ADC PARKS & GREENSPACE ARBORICULTURE

PLANNING APPLICATION: LU/118/14/PL

ADDRESS: Former Bodyshop Offices Courtwick Lane Littlehampton BN17 7LR

BRIEF DESCRIPTION: Change of use & extension of part of former office building to a G P Practice with associated parking, landscaping & highway works.

10232
Surgery, Courtwick Lane, Littlehampton
Tree Survey Plan

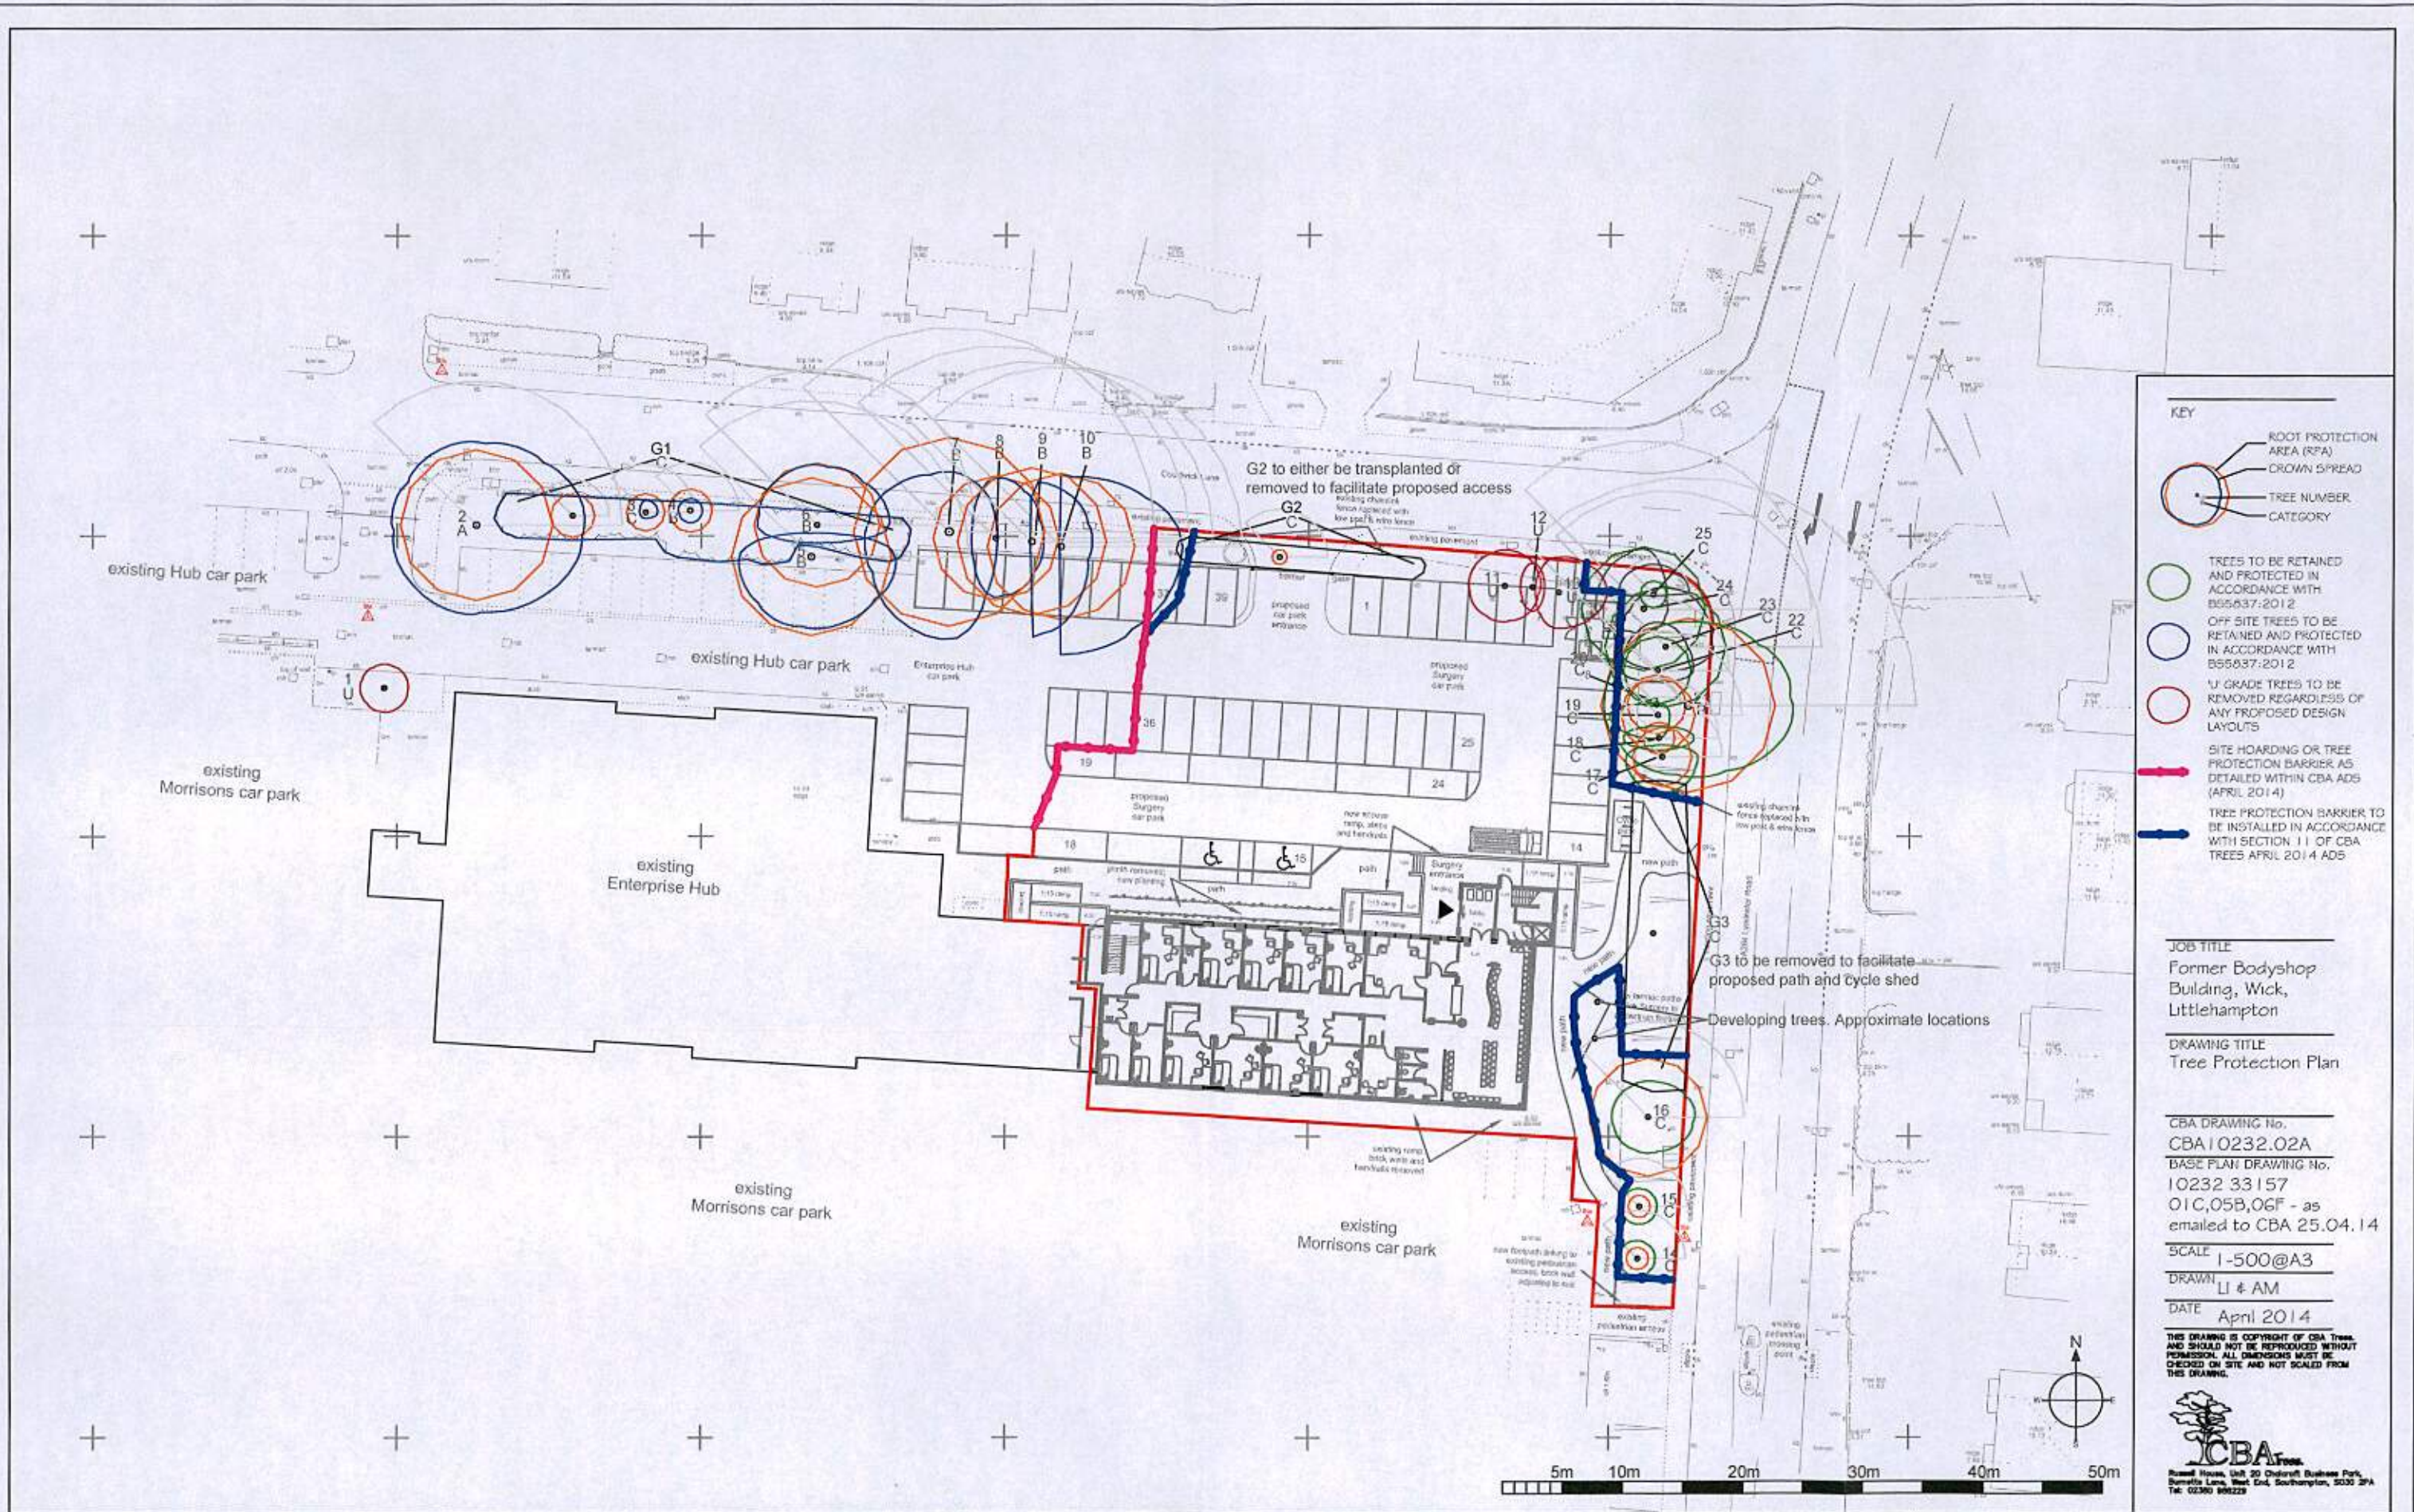
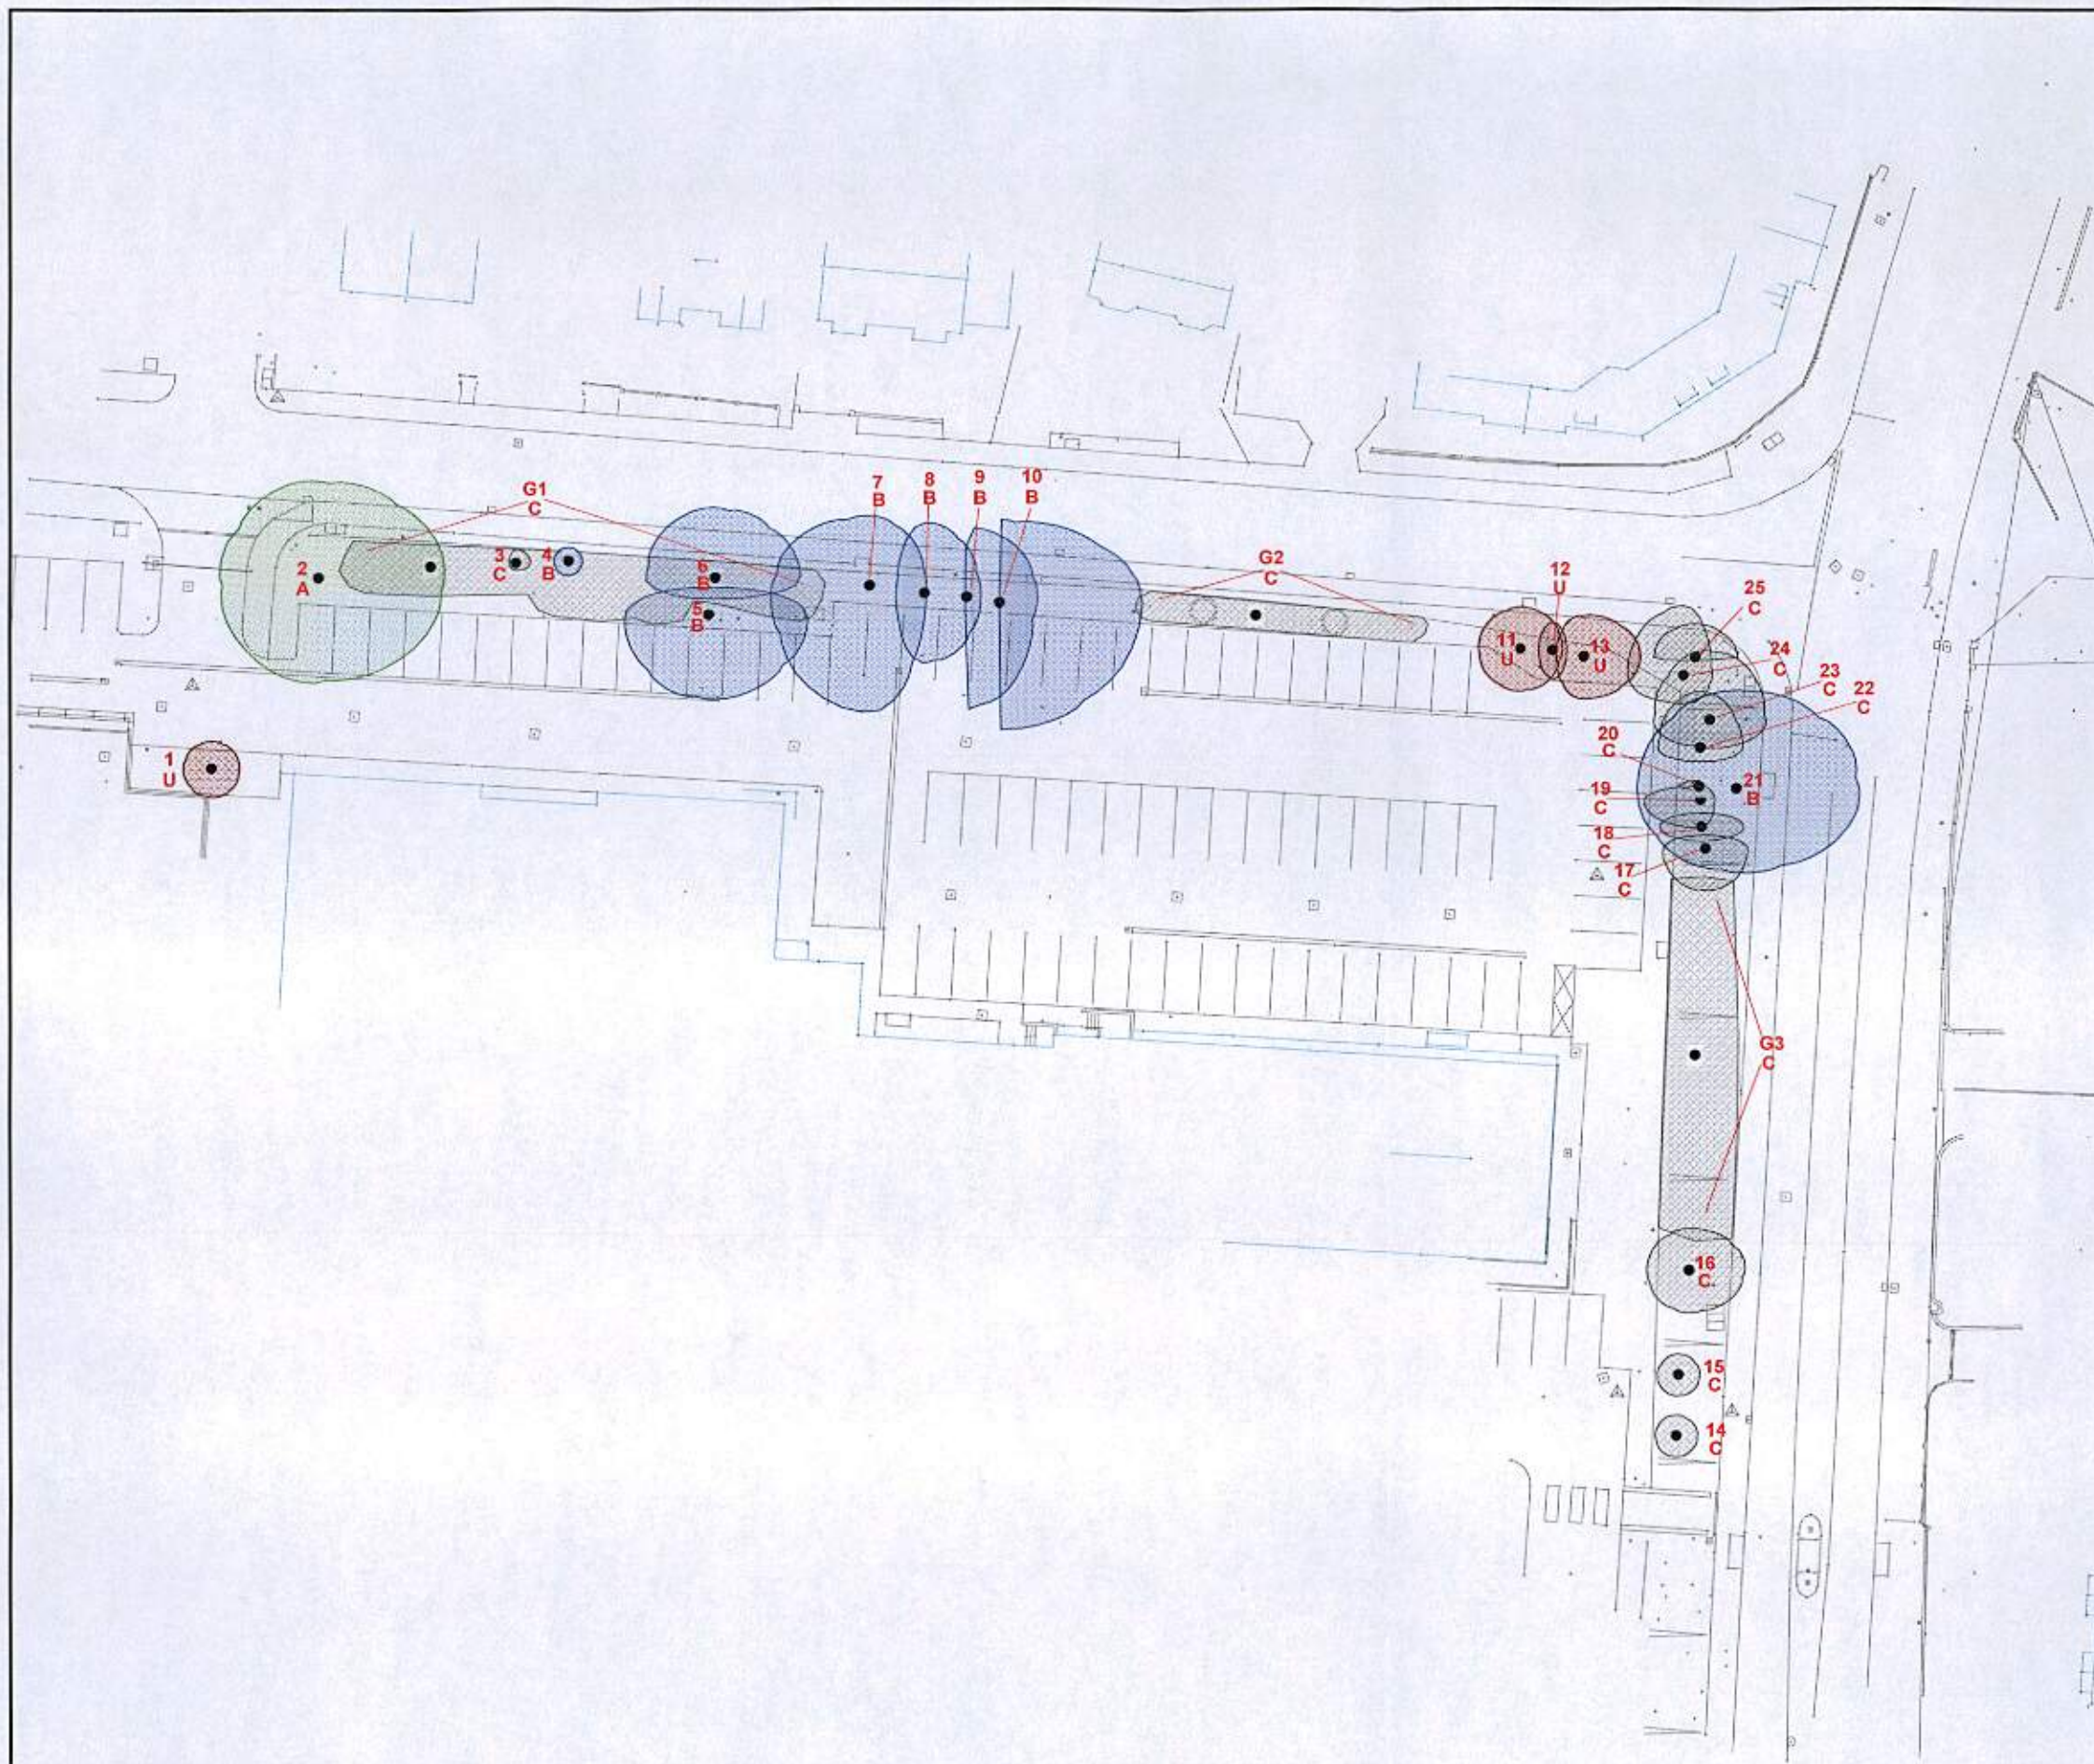
- The ADS indicates the desire to remove some existing groups of trees (group 1 and group 3). These groups are due to be removed to allow for extra vehicle access points to be installed. These groups are made up of a mix of semi mature species (Mainly Hawthorn/Elder/Sycamore) that are not in particular good condition or are not showing much arboricultural merit. These trees have correctly been assigned to the category C (low quality) and thus there is justification to remove as required.

- As for group 2 (3 x newly planted Limes, and 2 x newly planted Pines), an aspiration has been expressed to try to transplant these trees within the site. There is however, no real detail given of where exactly these trees would be planted from the ADS. According to section 6.2.2 of the BS 5873:2005 '*areas for future planting should be plotted on the tree constraints plan and protected from damage, especially soil compaction due to construction activity.*' Therefore the mitigation afforded to the

- T-1, T-11, T-12, and T-13 have also been designated for removal. T-1 and T-12 are standing dead, therefore should be removed. Also T-11 and T13 are in a very poor condition, with a poor growth habit and should be removed (according to 4.3 of the BS5837:2005).
- Justification is given to outline the ambition retain of most of the existing specimens. This is an important aspect of the application as the existing trees highly visible where they are located. They also screen the main highway quite effectively from gaze and noise.
- It has also been outlined the used of static protective fencing will be erected to confine the RPA areas to create the construction exclusion zones that are required by the BS5837.

- If however, the attempt to relocated group 2 fails, **a restocking regime should be instigated.** This would see similar trees (species, size, form, and lifecycle) planted in the desired location. **As highlighted above, this location is to meet the criteria set out in section 6.2.2 of the BS 5837:2005, if the intention is to plant in an area of the site that will see construction disturbance in the works process.**

- **All works are to comply with BS5837:2012 – Trees in relation to design, demolition and construction –Recommendations**
- **I do feel it necessary to ask for a site visit to be done by a representative from the Local Authority after the mitigation (protective fencing etc.) has been established, but before any construction has begun. Once the mitigation has been checked and approved, future inspections of the site can be arranged with the applicant.**
